BN14/1427

I refer to the Gateway Application for the Bylong Coal Project near Mudgee.

Advice prepared by the NSW Office of Water for the Minister for Primary Industries

Bylong Coal Project – Application for Gateway Certificate

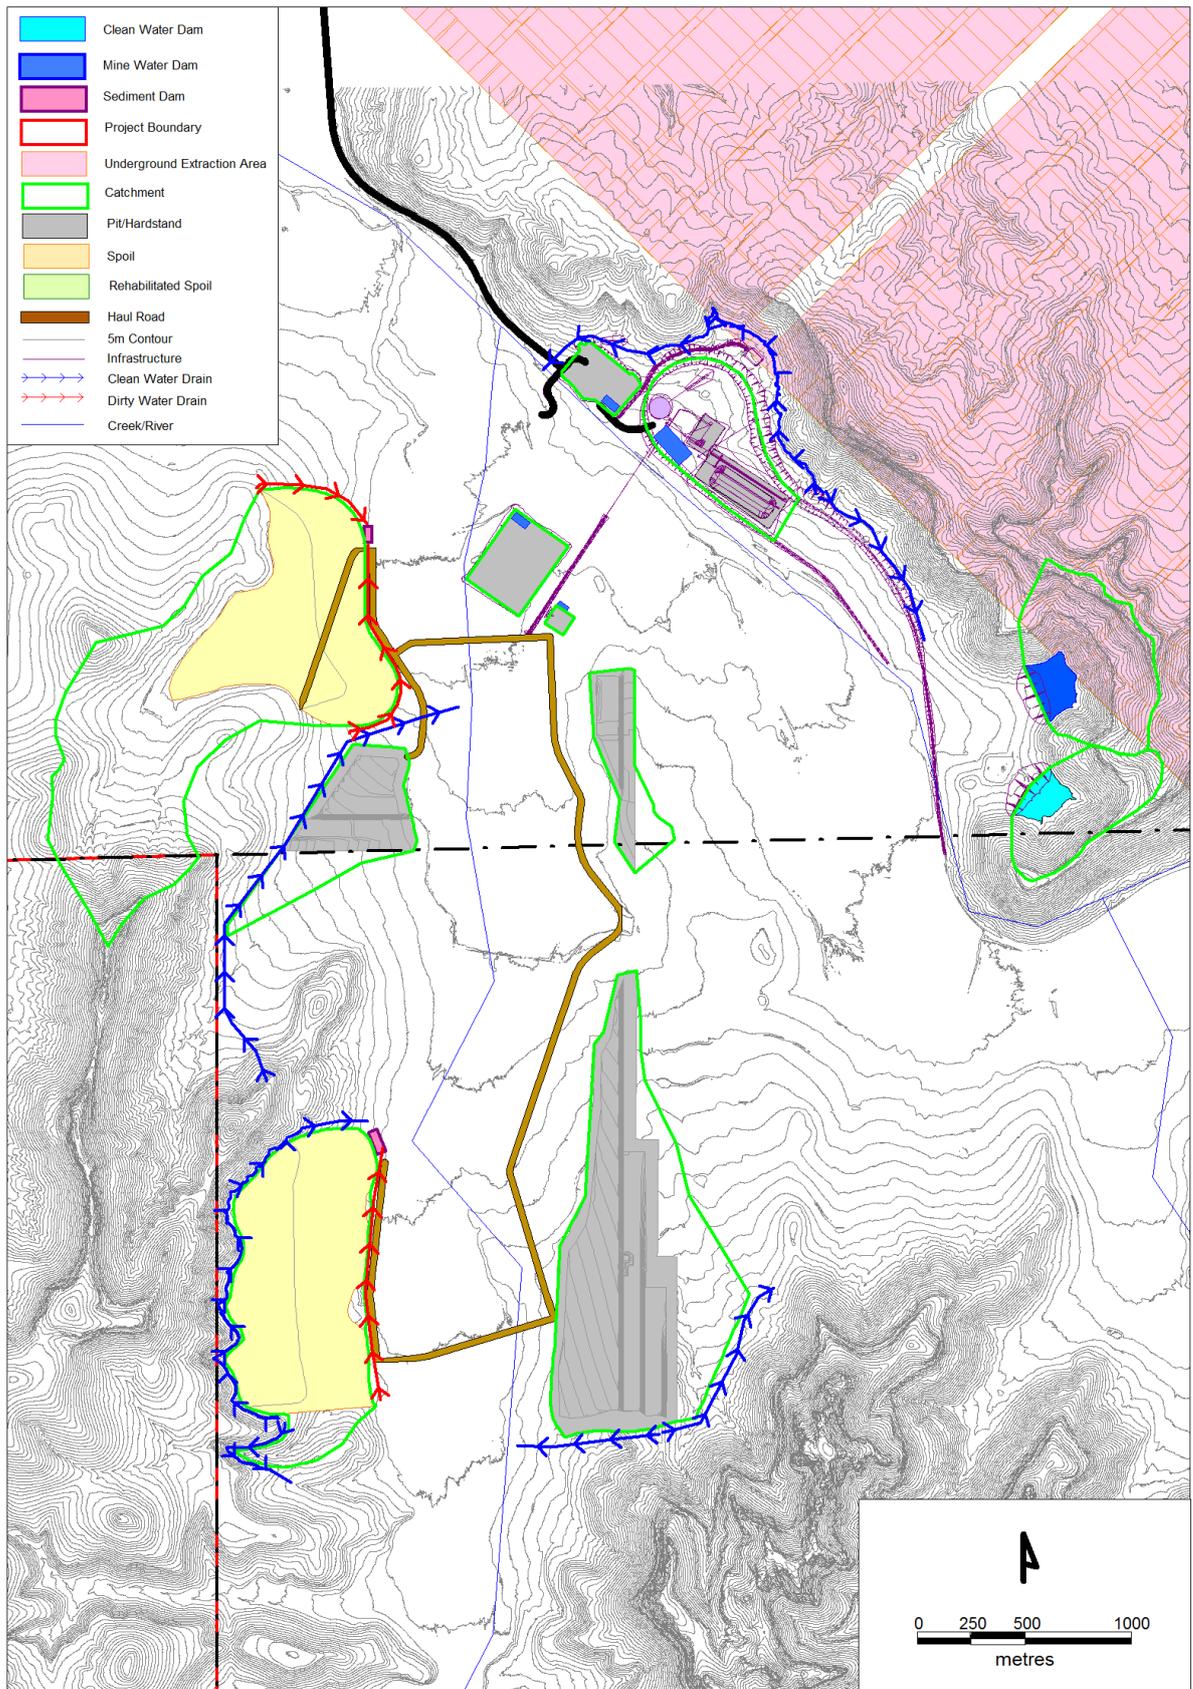
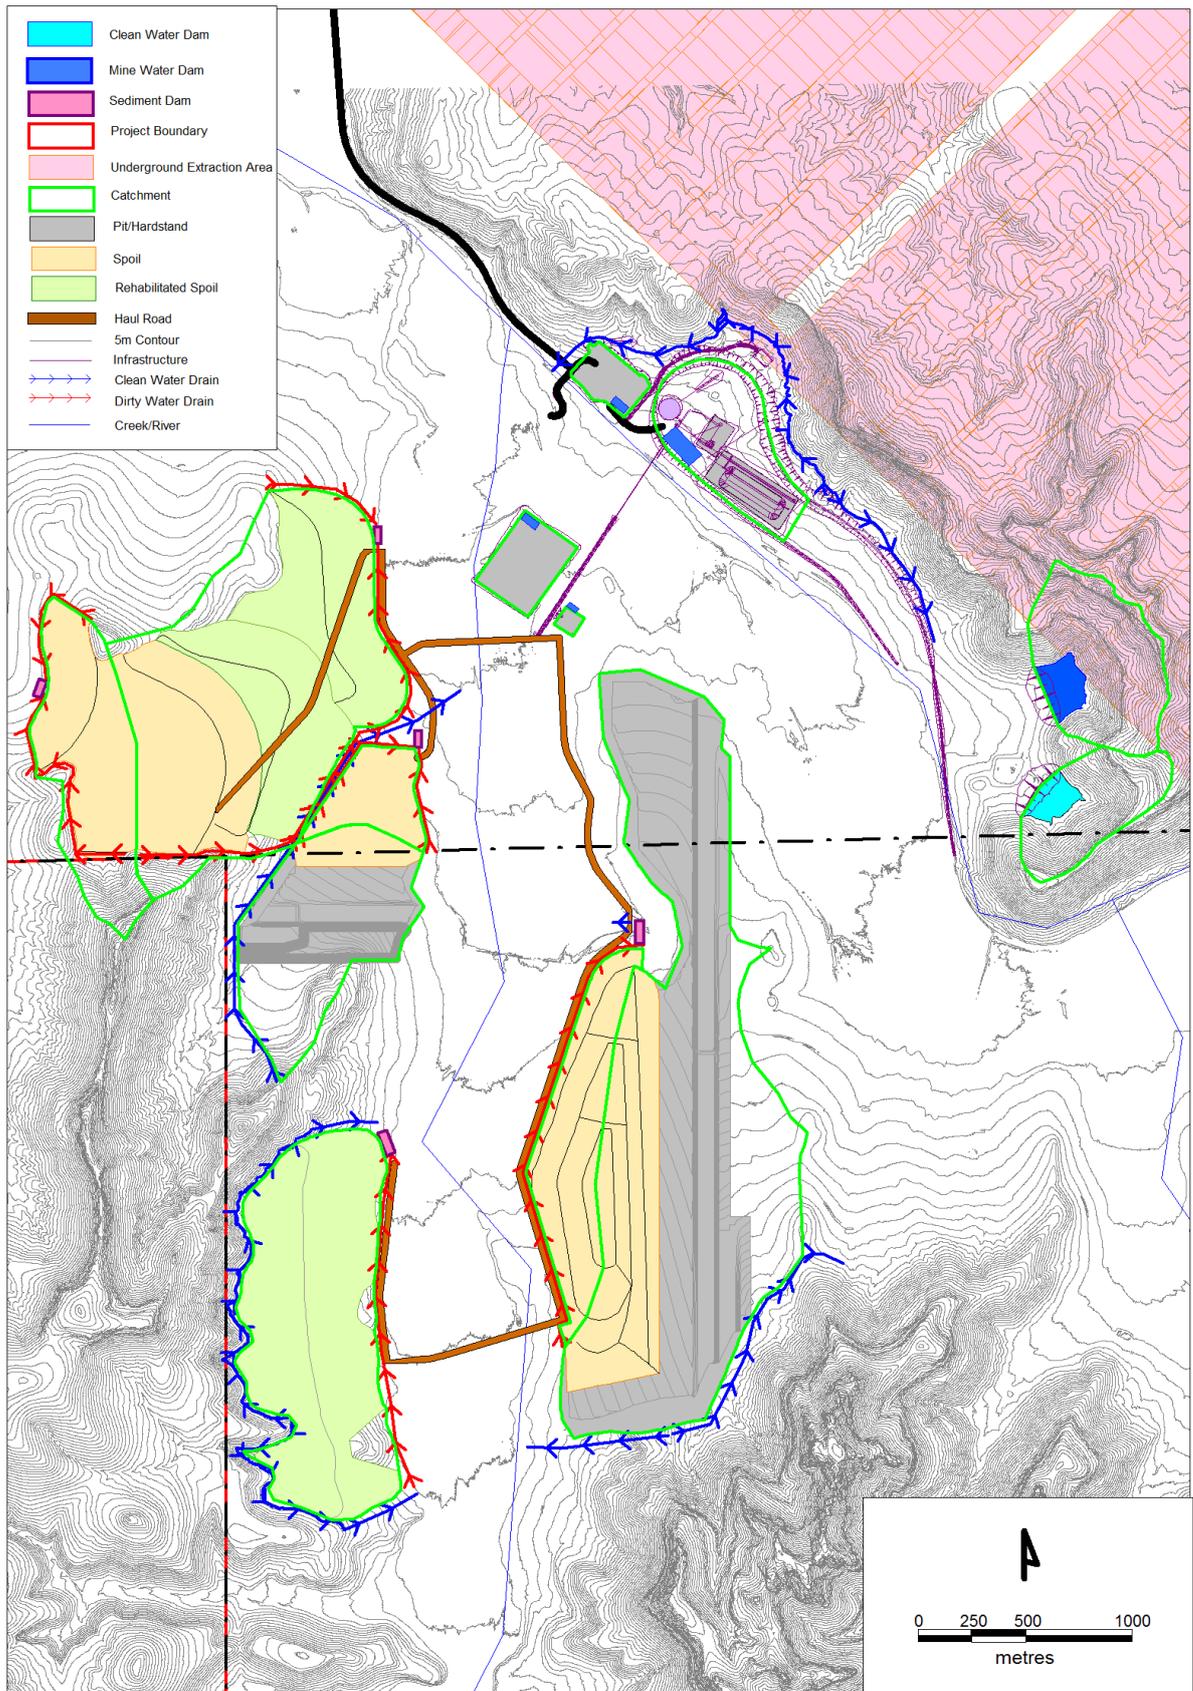
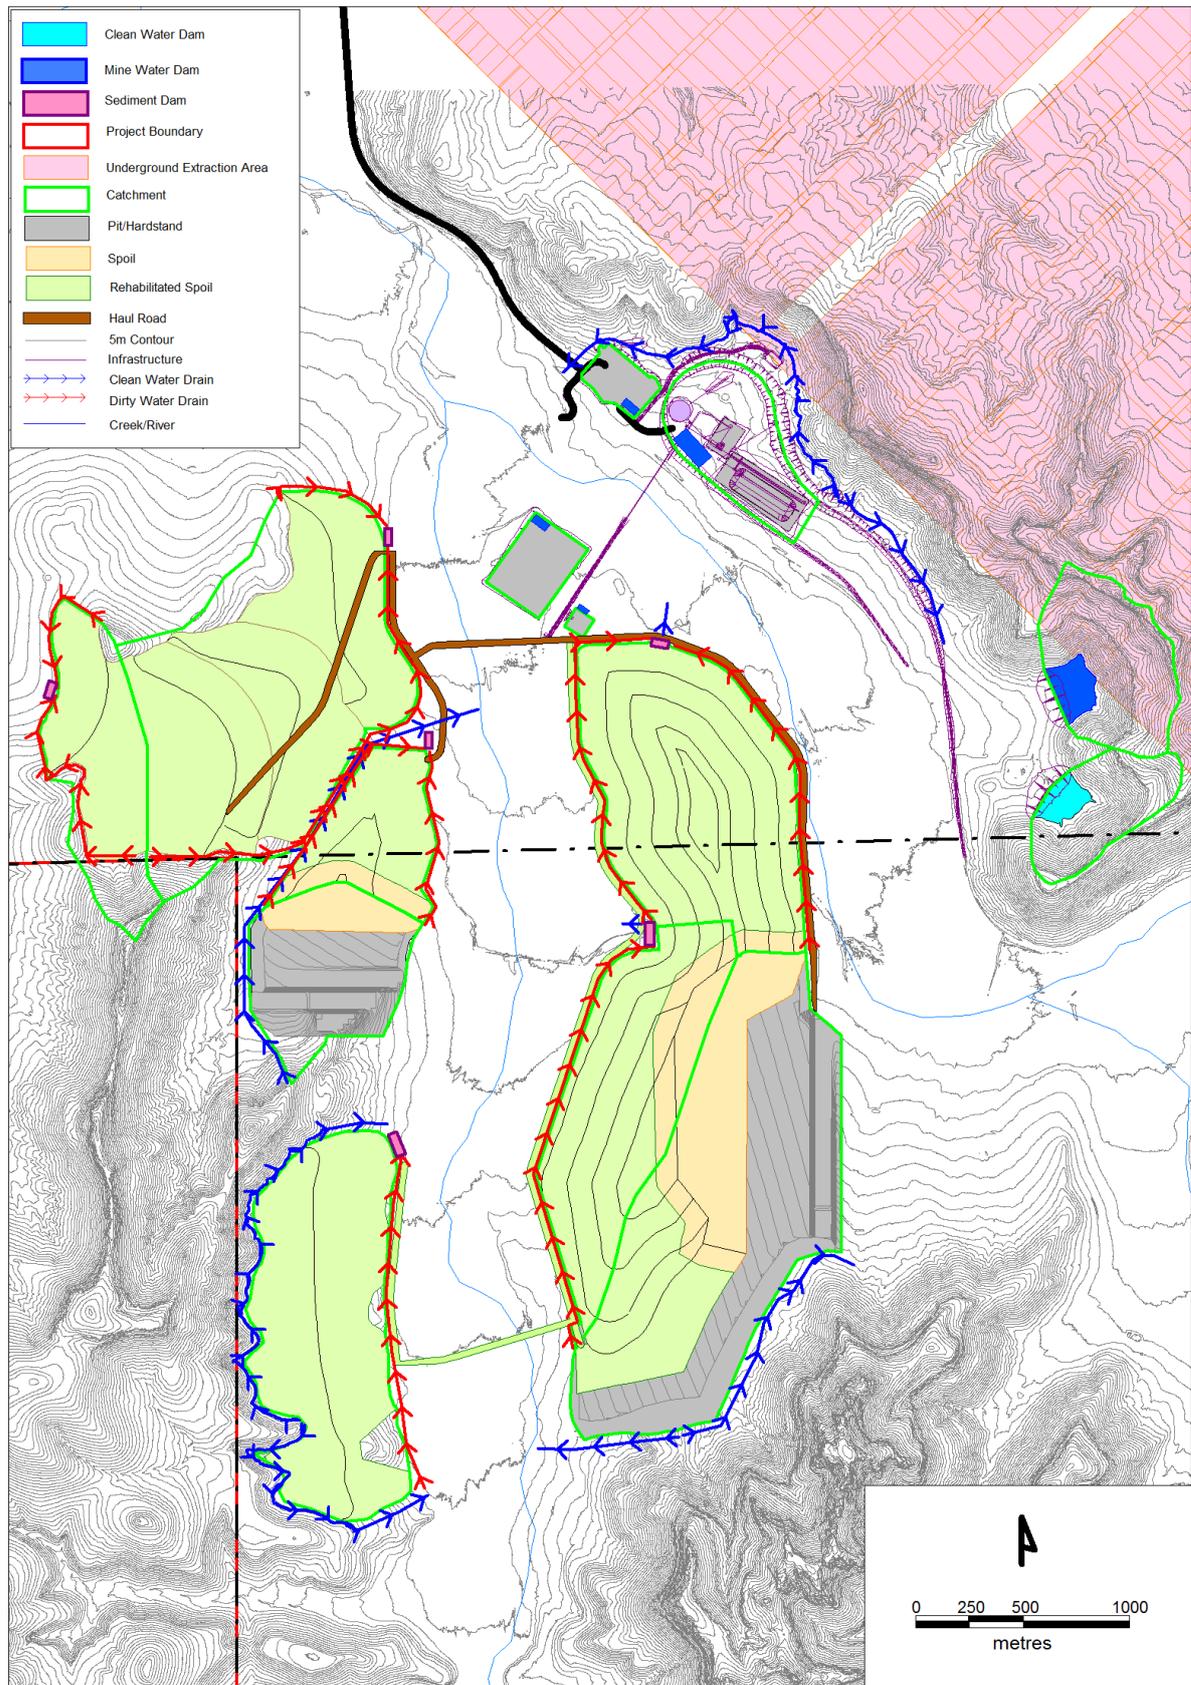
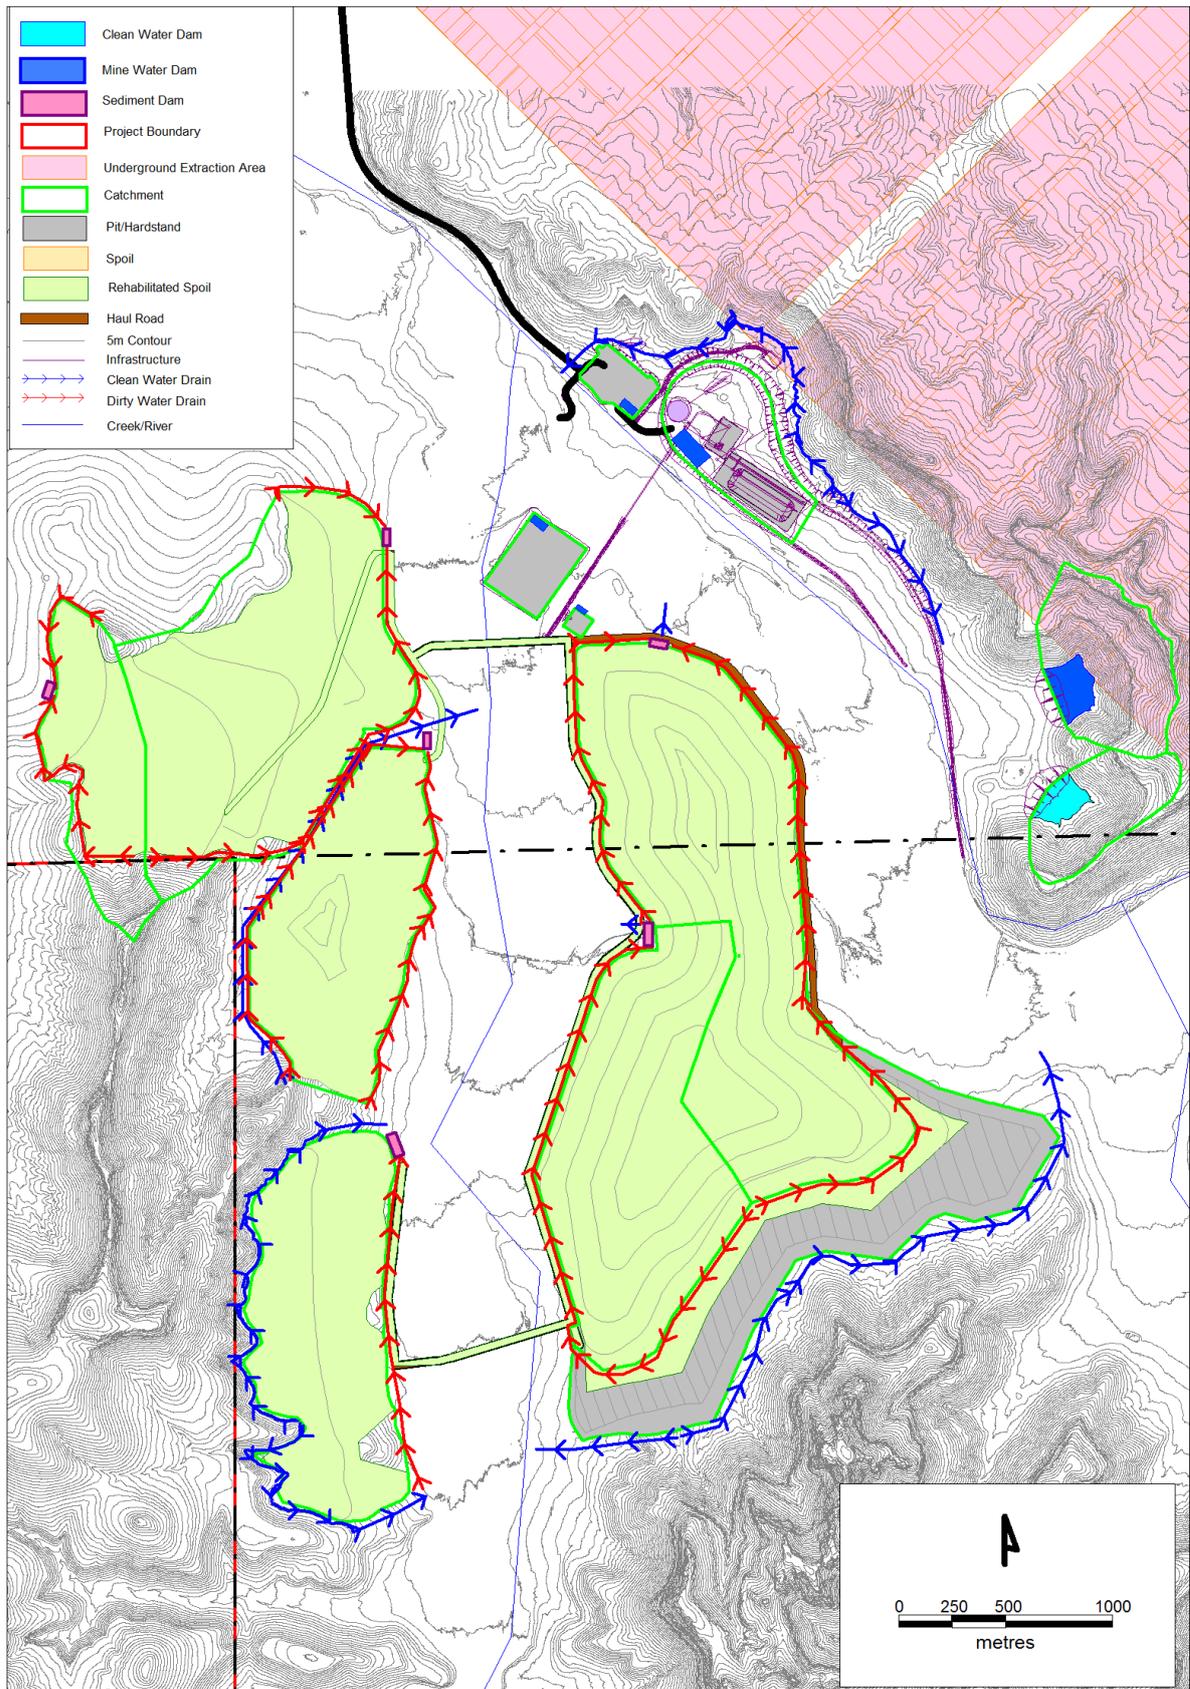
The proposed future work will inform the risk. However, it is noted that along the northern area of the Western Open Cut where the emplacement on colluvium is proposed, there is only one alluvial monitoring bore which is located on the opposite side of Lee Creek. It would be recommended that additional monitoring be established in this locality but to the west of Lee Creek so as to monitor long term potential changes in alluvial water quality. Mitigation work should be a requirement if a rising trend in salinity was identified in this locality.

- (ii) Additional bore monitoring sites be established along the Western Open Cut where mine spoil is proposed to be placed on colluvial material. Mitigation work should be a requirement if a rising trend in salinity is identified in this locality.
- (iii) KEPCO make provision for continued access to Office of Water infrastructure located on KEPCO land.
